Subject: 2025/90033 at location adj, 916, Halifax Road, Hartshead Moor, Cleckheaton, BD19 6LR

Please see ecological commentary below.

Figure 1. Total biodiversity units of the site, before and after development by Barnes Homes

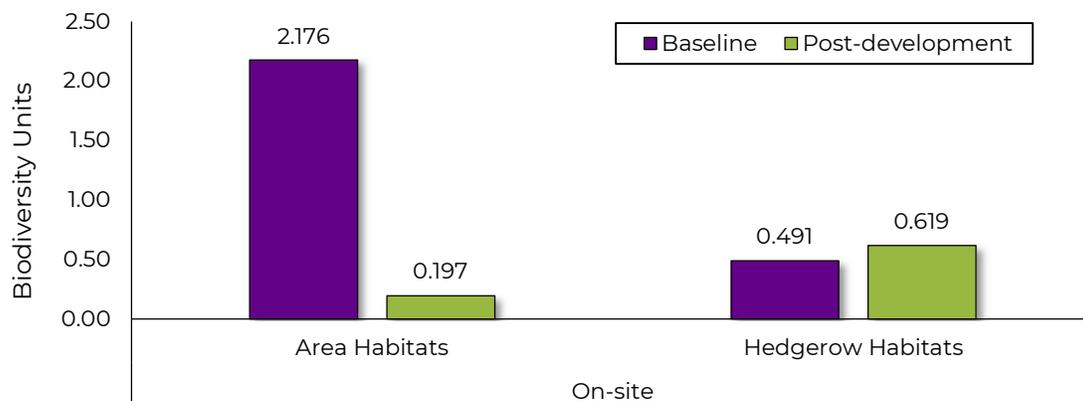
However, it is also noted that there is a net loss of 1.98 habitat units. The report shows no plan to make up for the shortfall of 2.2 units for the statutory 10% net gain.

We recommend the applicant provides at least an outline of the intended route to achieving net gain.

To be confirmed once a plan is provided to achieve overall 10% net gain.
